CITY OF ALBUQUERQUE

March 24, 2022

RE: 1717 Archuleta Dr. NE
1717 Archuleta Dr. NE
Grading and Drainage Plan
Engineer's Stamp Date: 5/24/21
Hydrology File: J23D021

Based upon the information provided in your submittal received 1/4/2022, the Grading & Drainage Plan is **not** approved for Building Permit. The following comments need to be addressed for approval of the above referenced project:

SIDEYARD RET. WALL SECTION

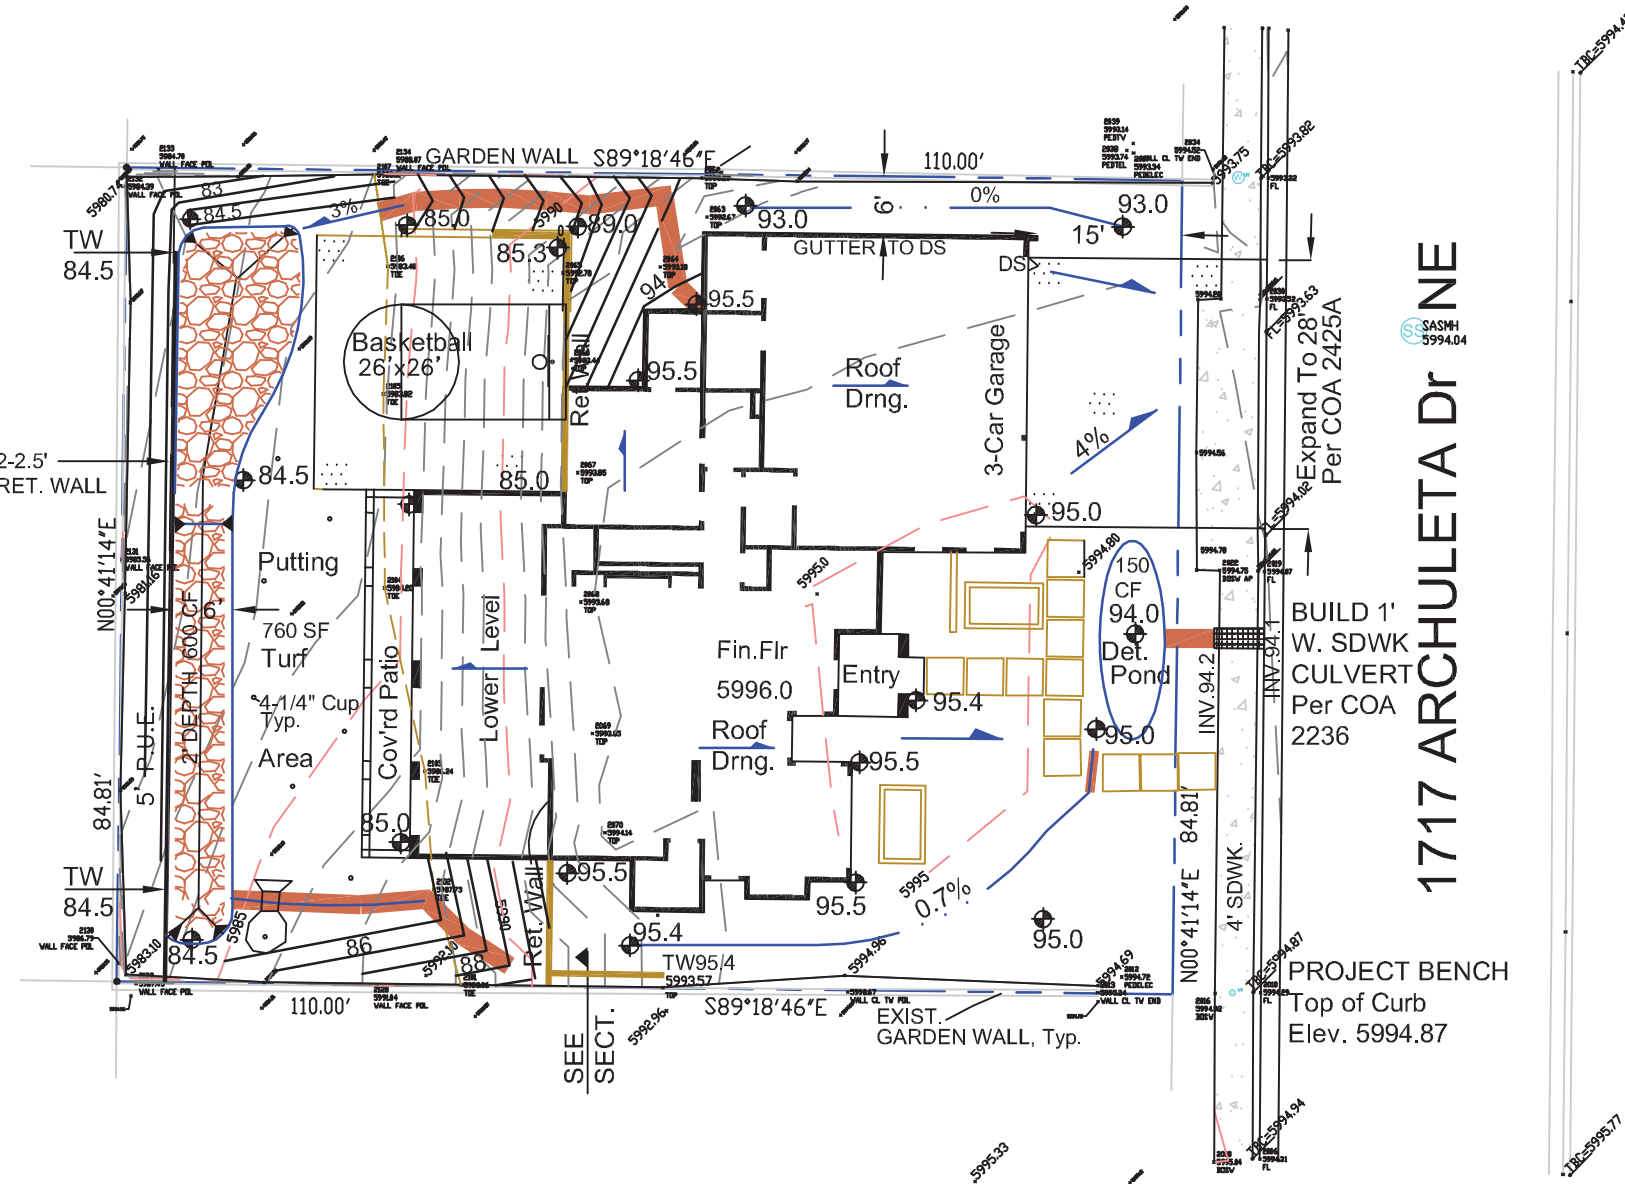
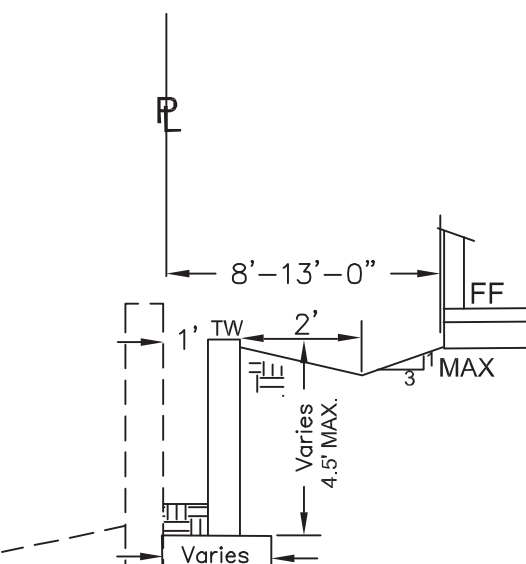
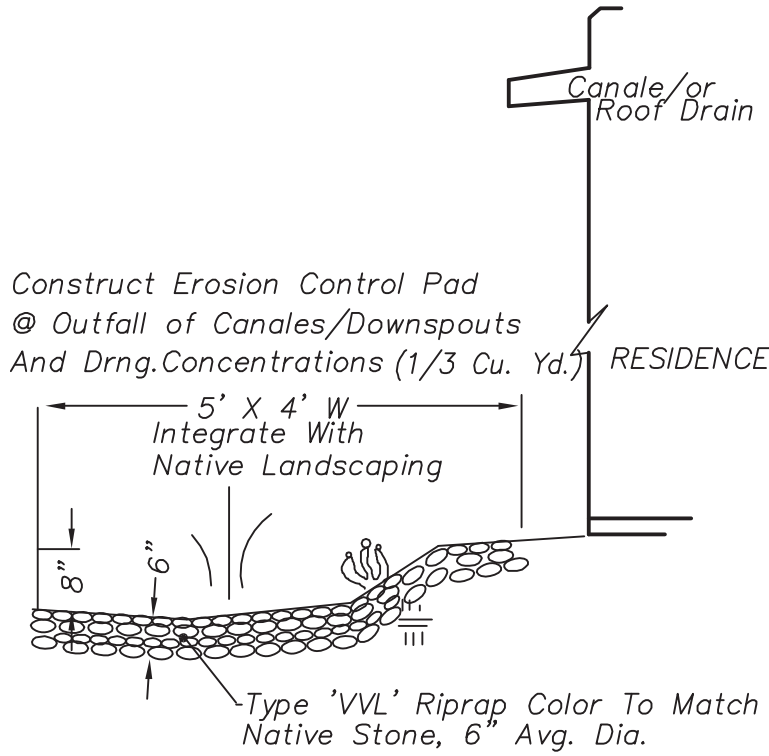
1. Can you please note if this is a stem wall as part of the foundation of the home? (below image)

- i. Please provide top of wall and bottom of wall elevations. Provide a detail please.
2. Please include bottom of wall elevation along the PUE. Provide a cross section/detail showing the PUE and ensure the footing is outside of that.
 3. You are calling out basins, please provide a basin map and clearly show how flow is getting to each proposed pond.
 4. Please clearly label what the required retention volume is needed and what is provided for each basin.
 5. Please include project benchmark and datum
 6. Please include the FIRM.
